KIRKLEES METROPOLITAN COUNCIL INVESTMENT & REGENERATION SERVICE

DELEGATED DECISION FOR DISCHARGE OF CONDITION A.4 - NOTIFICATION OF A PROPOSED ENLARGEMENT TO DWELLINGHOUSE

Reference no.	2024/HH/90069/W
Site Address	14, Lincroft Avenue, Dalton, Huddersfield, HD5 8DS
Description	The proposal is for erection of single storey rear extension. The extension projects 5.1m beyond the rear wall of the original dwellinghouse. The maximum height of the extension is 3m, the height of the eaves of the extension is 2.8m
Recommending Officer	Molly Storer

Proposed Ground Floor

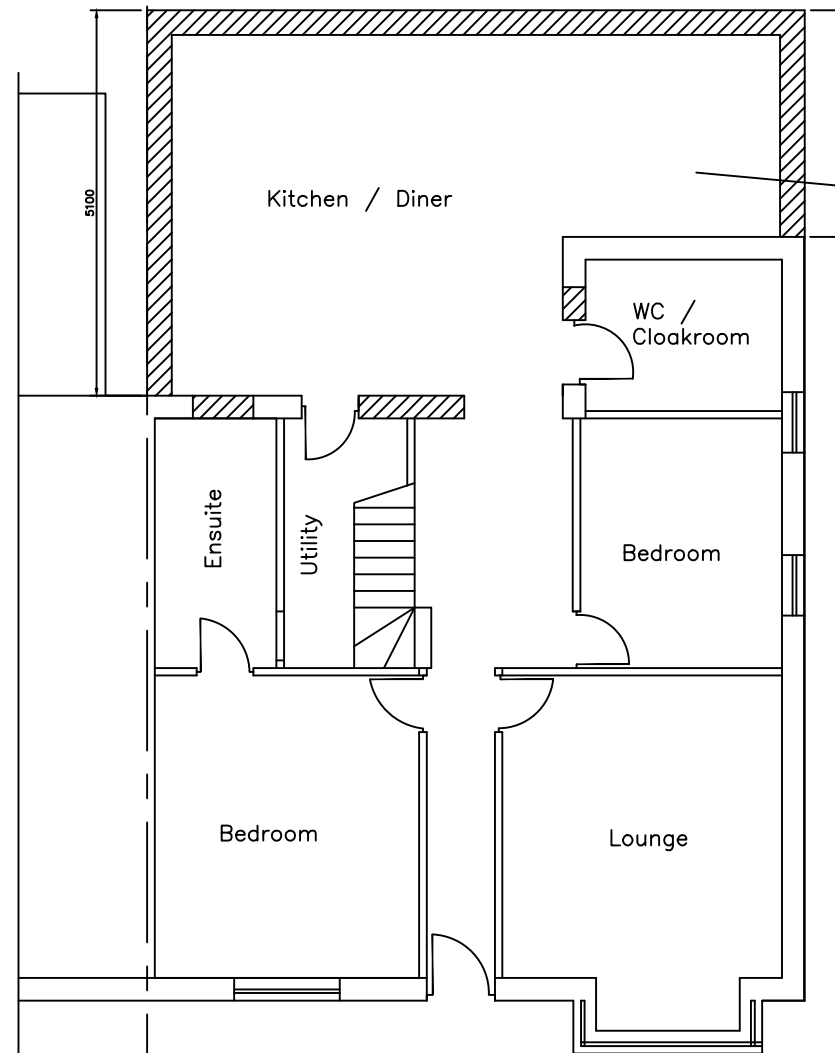
The proposed extension projects from the rear of the original dwellinghouse by 5.1 metres along part of the rear elevation and 3 metres beyond an existing part rearward projection. The Council's historical imagery dated 1958 indicates the existing rearward projection was original to the dwellinghouse. To further support this evidence is that the properties along Lincroft Avenue all have the same rearward projection indicating the original housing was built to a standardised house type. It can be seen from the existing projection that it is of sufficient scale and attachment to indicate the projection is part of the dwellinghouse and thus forms part of the original dwellinghouse.

The rearward projection therefore includes a side wall forming a side elevation of the original dwellinghouse when having regard to the Government's householder guide to permitted development rights (2019). Sub-paragraph (j), Class A, Part 1 of Schedule 2 of the Town and Country Planning (General Permitted Development) (England) Order 2015 (as amended) provides that development is not permitted under Class A where the extension which extend beyond a side elevation of the original dwellinghouse and has a width greater than half the width of the original dwellinghouse. In this case the submitted plans indicate the proposed extension extends along the whole rear elevation of the property and is therefore contrary to paragraph (j) of Class A and as such cannot benefit from a permitted development.

The proposed enlargement does not benefit from a general planning permission under Article 3(1) and Class A, Part 1 of Schedule 2 of the Town and Country Planning (General Permitted Development) (England) Order 2015 as the rear projection also extends beyond a side wall of the original dwellinghouse and has a width greater than half the width of the original dwellinghouse contrary to sub-paragraph (j) of Class A.
